3rd June 2021

Planning Application 2021/91914

Proposed Site Layout

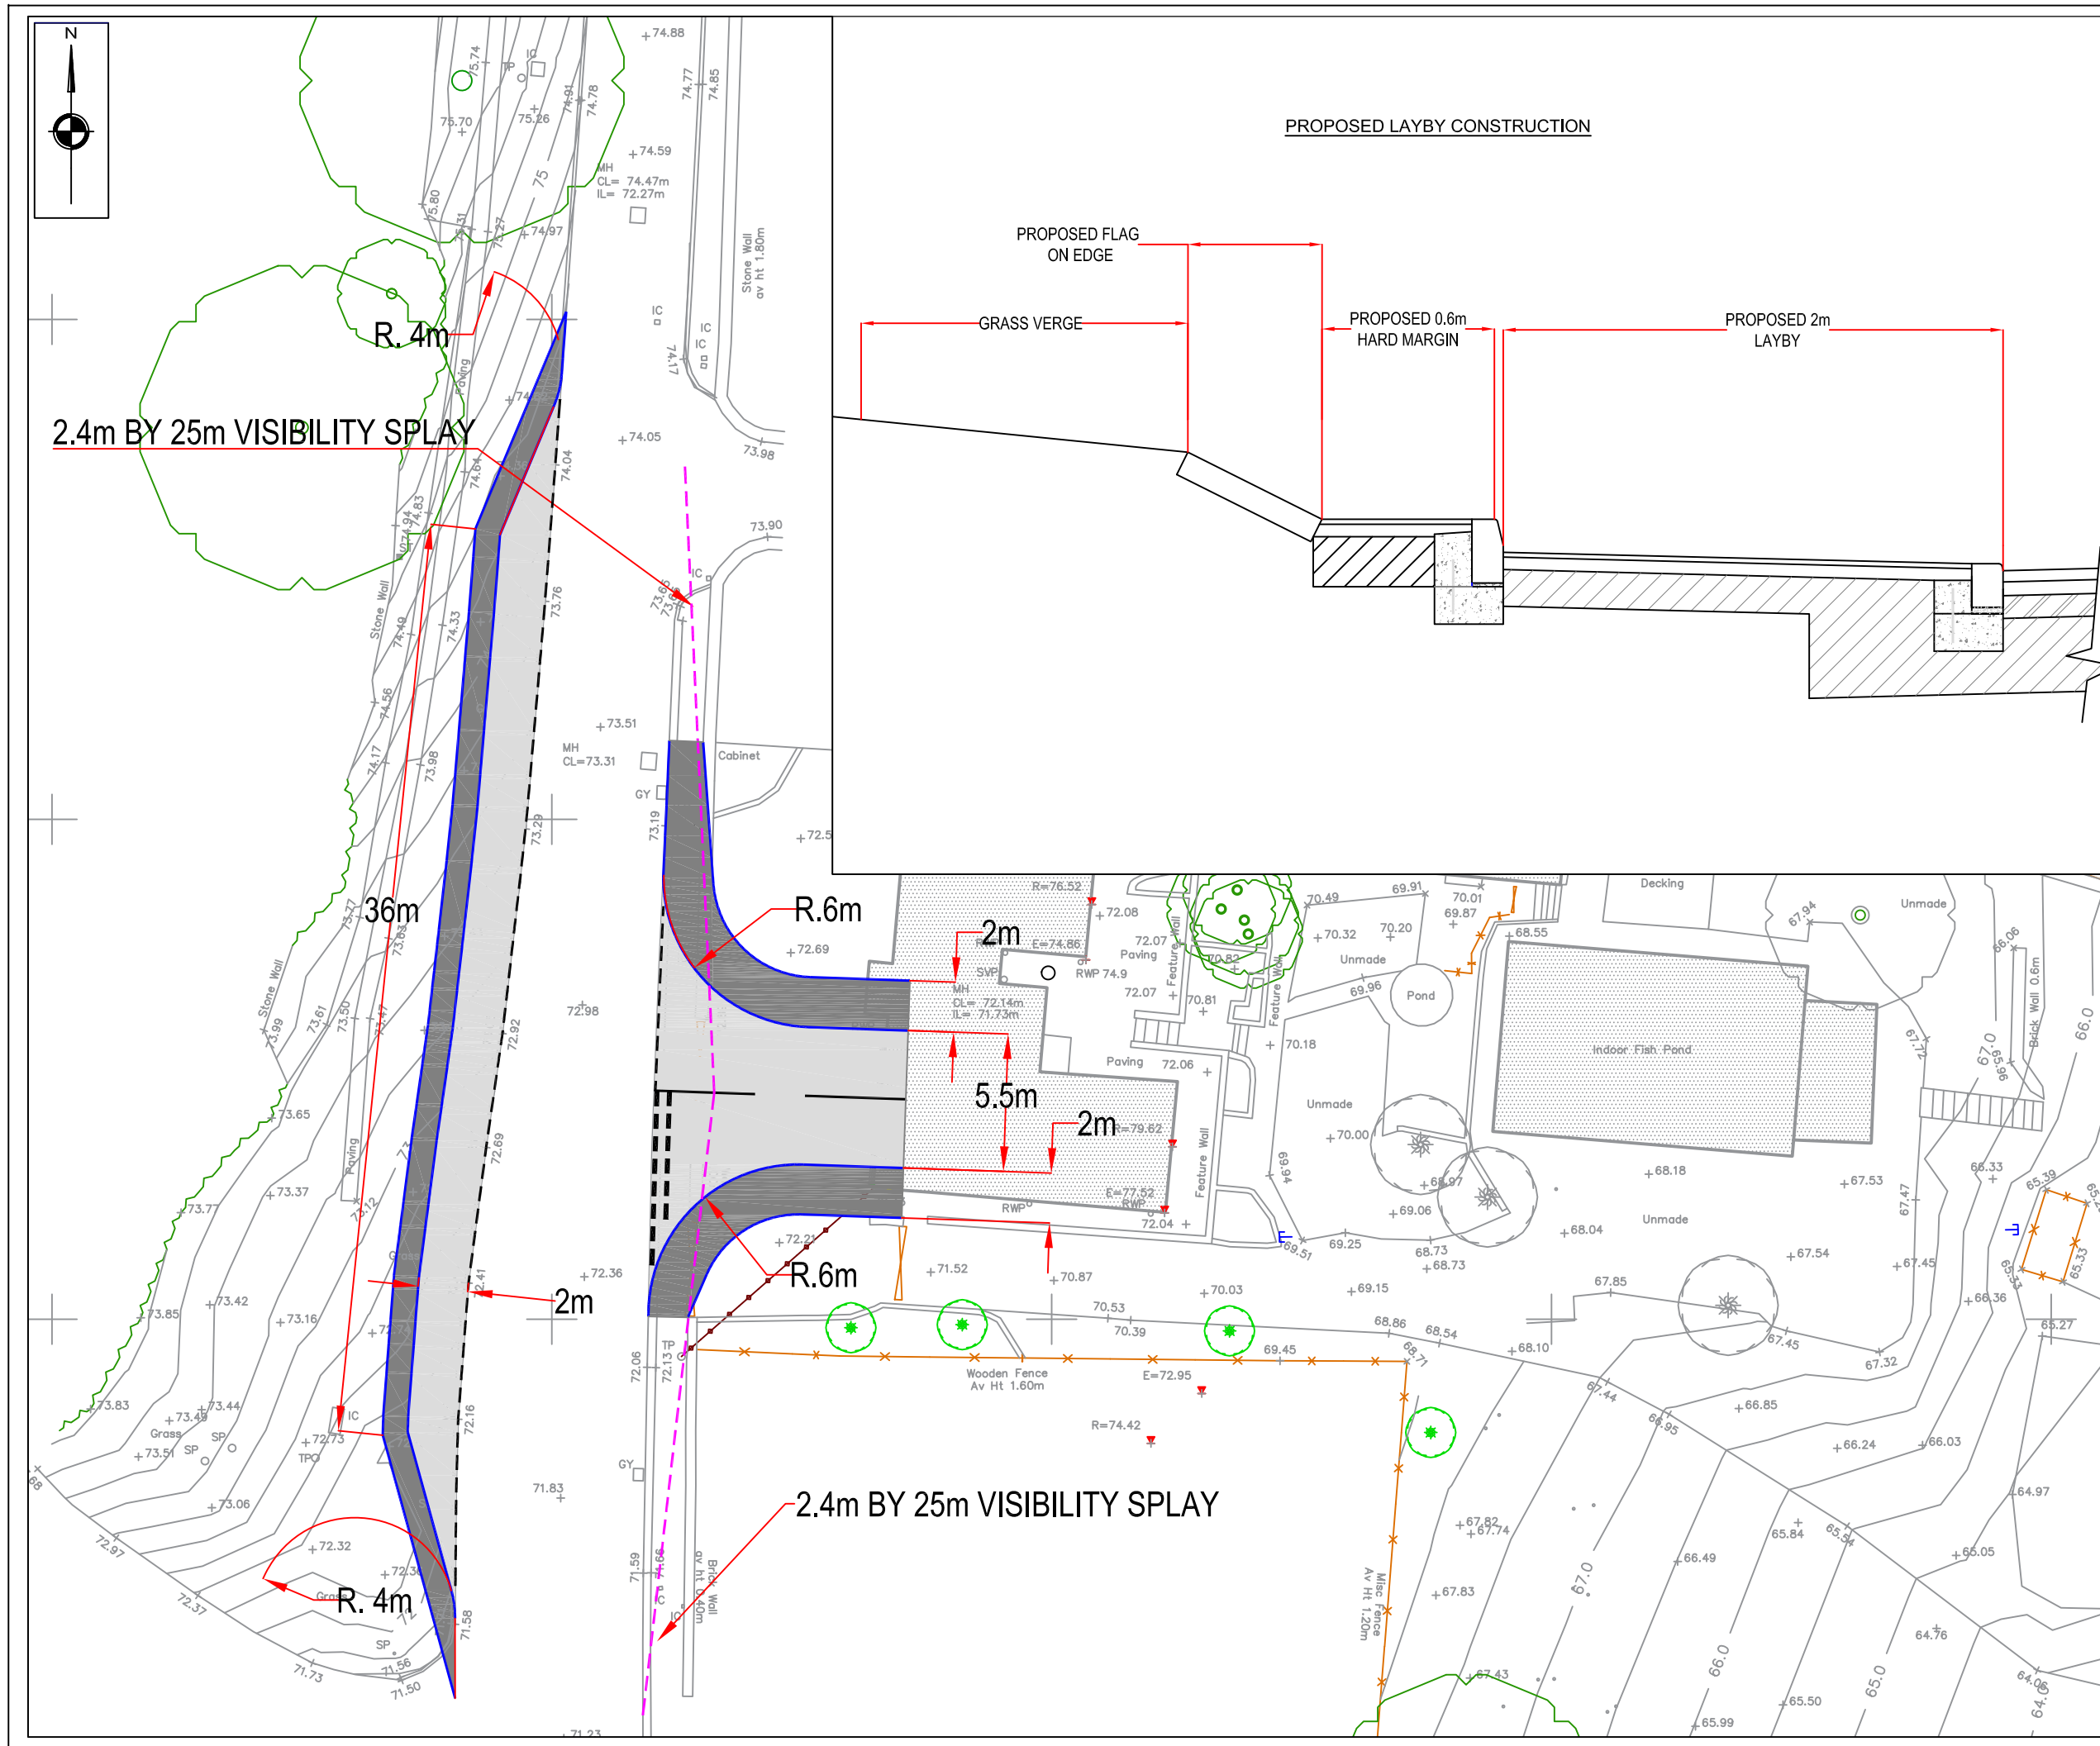
The site alone shows 96 cars can be parked on hard surfaces alone. That makes 200 journeys per day - the figures are totally unrealistic

- A 'pumping station' into an already inadequate Sewage system - which are against their own ^{Policy}

- No provision for the elderly or disabled, both are residents along the lane - don't people matter. Some of the pavement north (20 yards) from access are only 12" wide! (pushchairs wheel-chairs + Scooters are on the Road)
